Application no: H02-0430-15

Description: Proposed solar farm with associated infrastructure - approved under H02-0454-14.
Amendments to include revised panel and infrastructure layout

Amendment: Panel numbers decreased, substation significantly
reduced in size and Inver/Transformer Pods revised

ACKNOWLEDGEMENT OF AMENDMENT

Substation Plans and Elevations

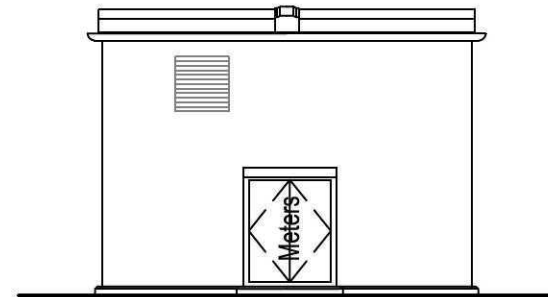
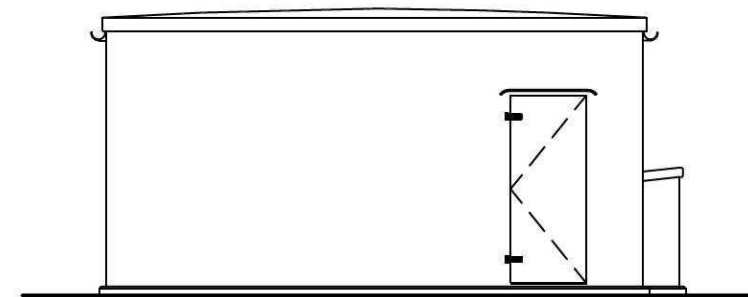
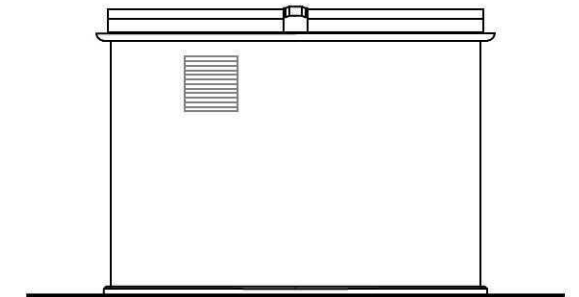
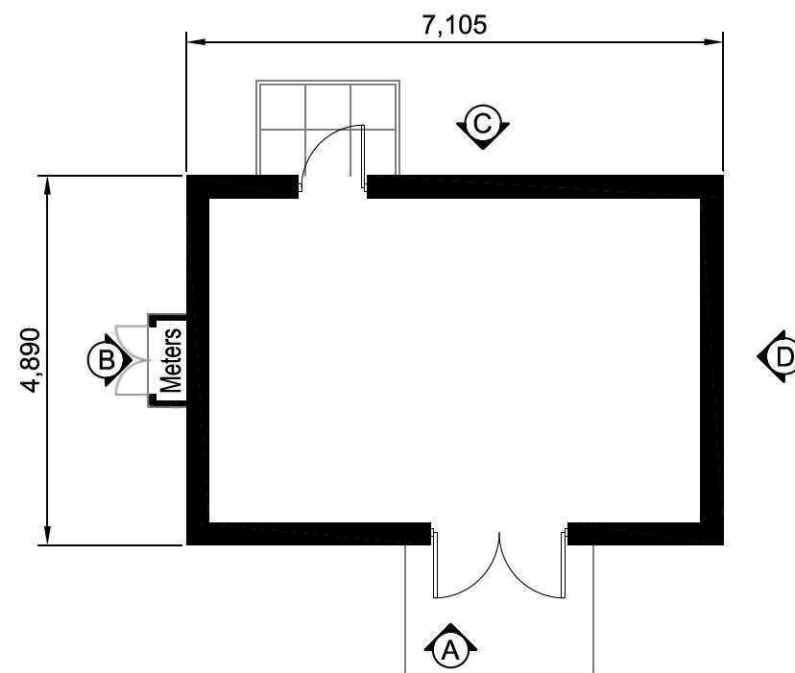
1. Panel numbers have decreased from 61,200 to 57,600, all of the panels will be at 15 degrees 4 in landscape, this reduces the overall height of panels to 1.9m high.
2. The large approved substation is significantly reduced in size, due to the fact that the DNO Western Power Distribution has revised their design.
The equipment remains the same but is housed in different buildings.
3. Inver/Transformer Pods have been revised, we have moved away from the bulky containerised solution, again all the equipment remains the same.

Drawing Title:
 Site Layout Plan

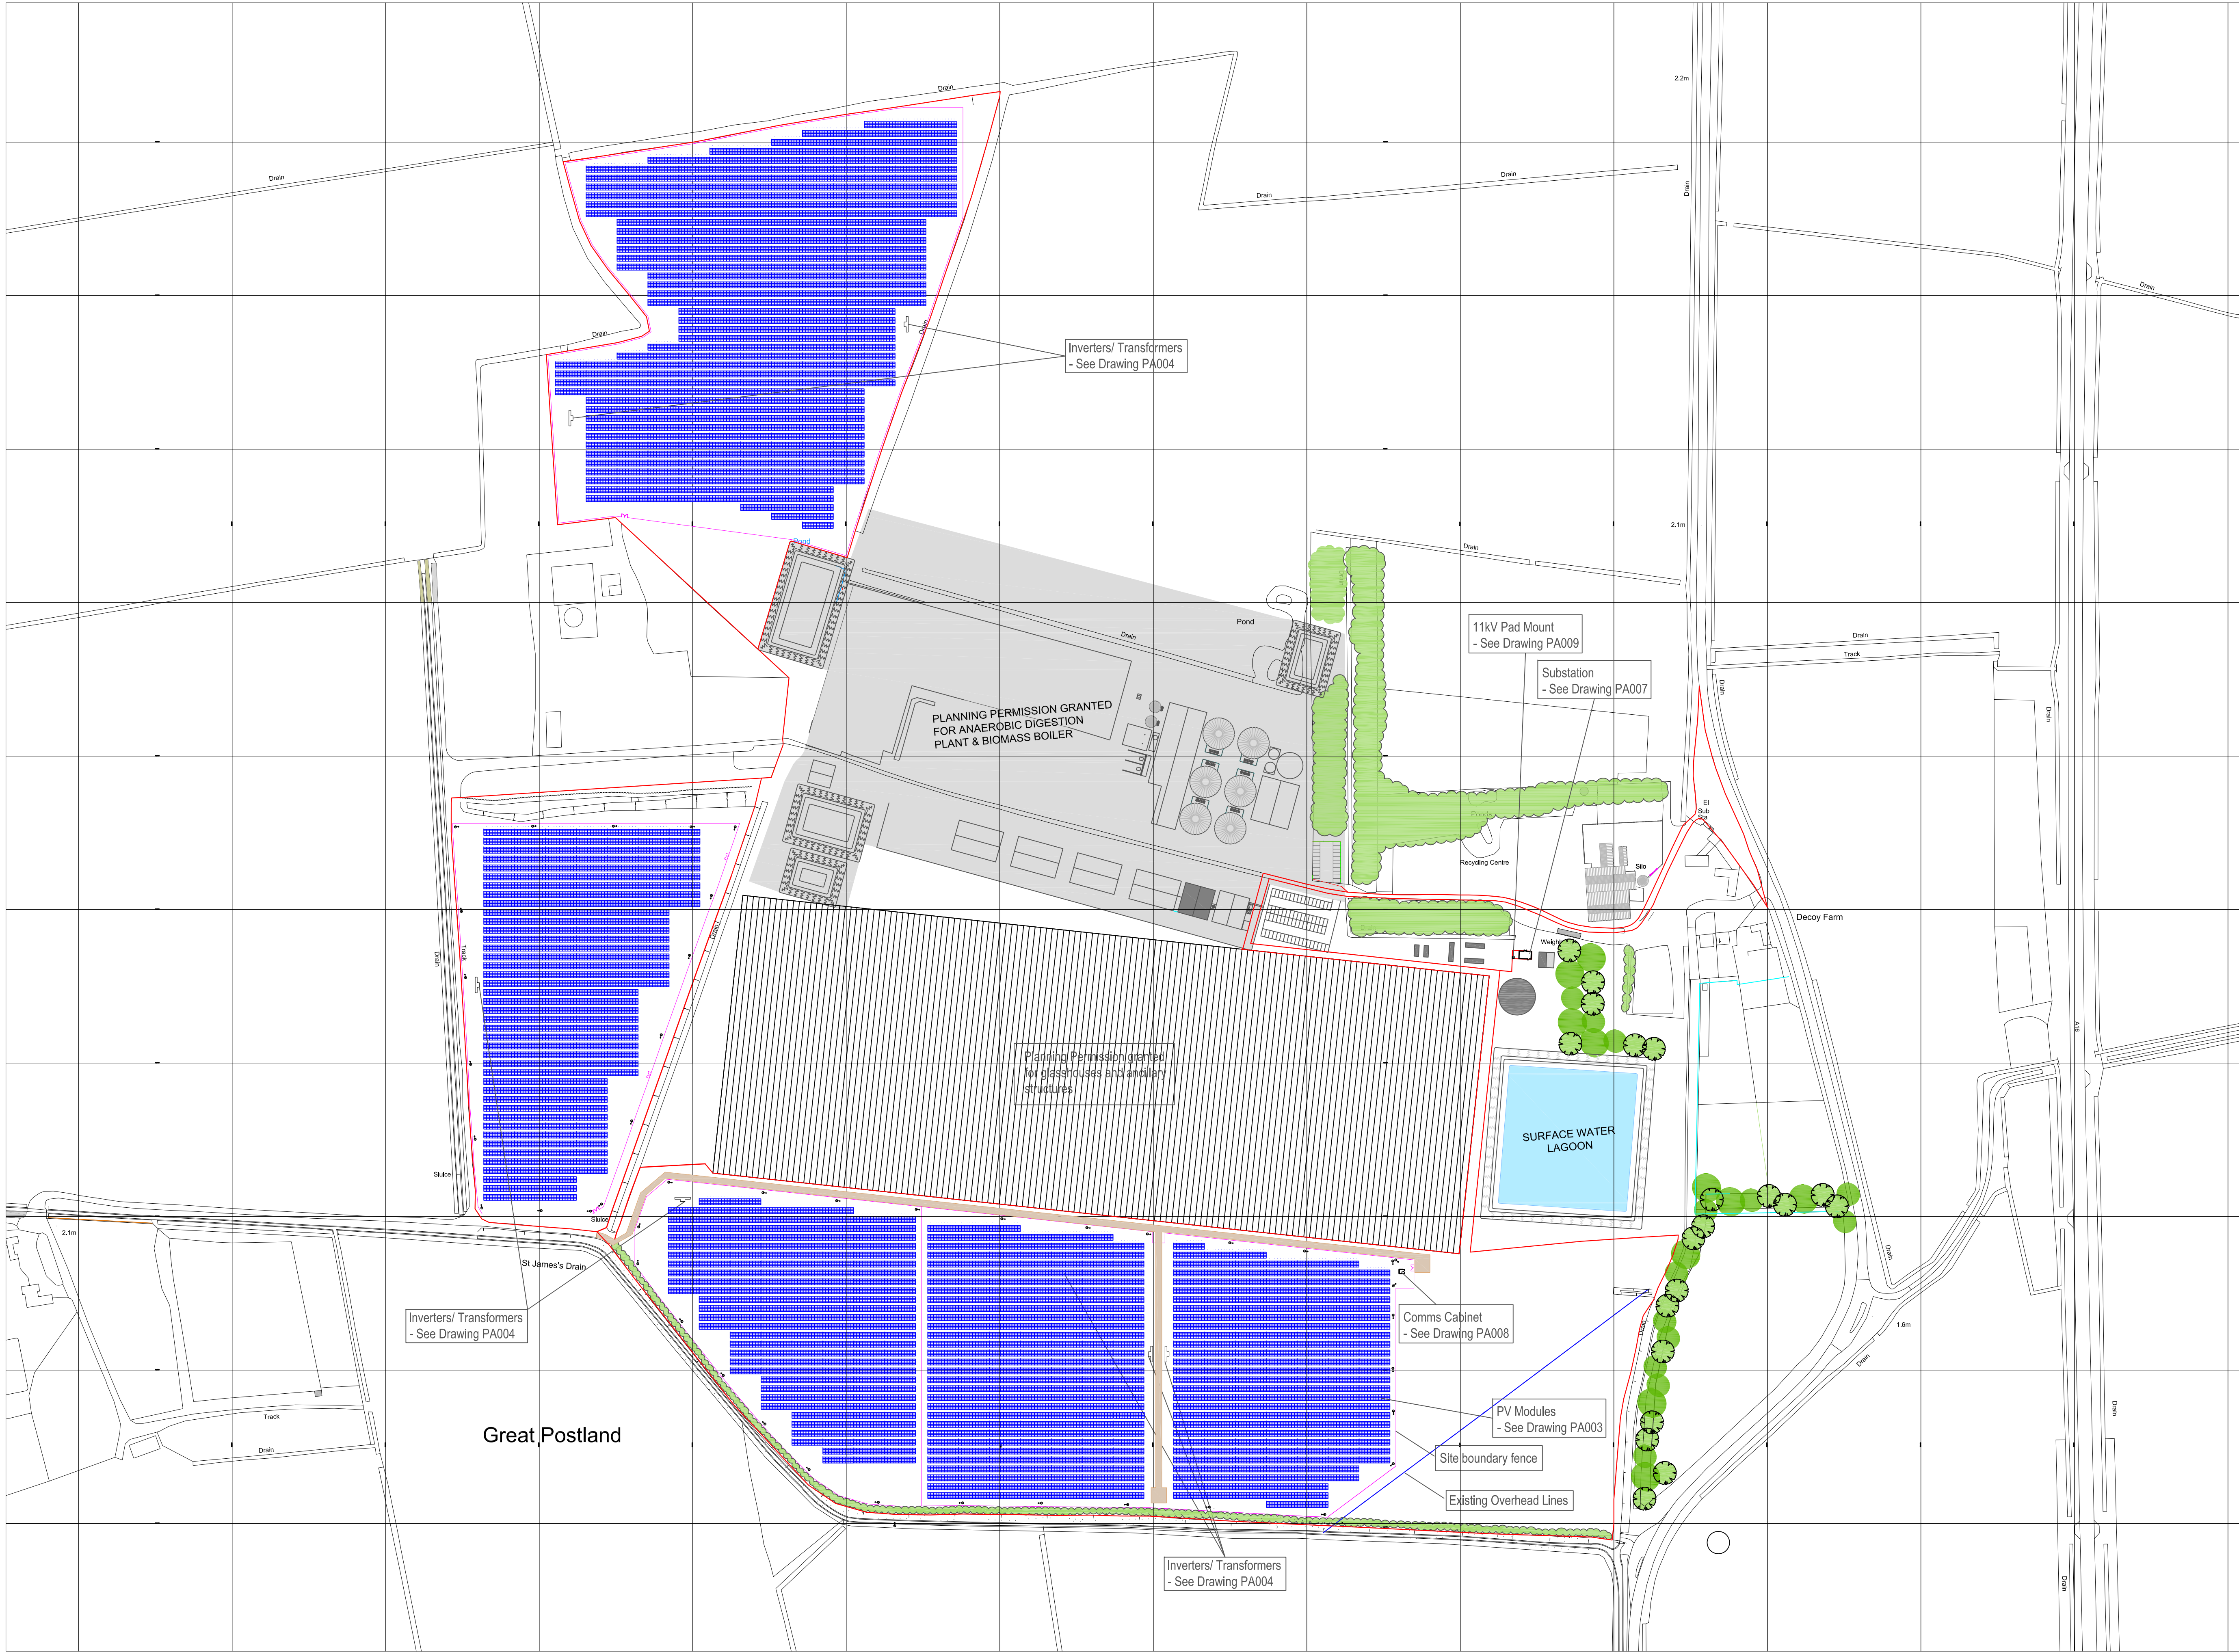
The changes have decreased the volume of built form by 195m³, increased the separation distance to the road by 150m.
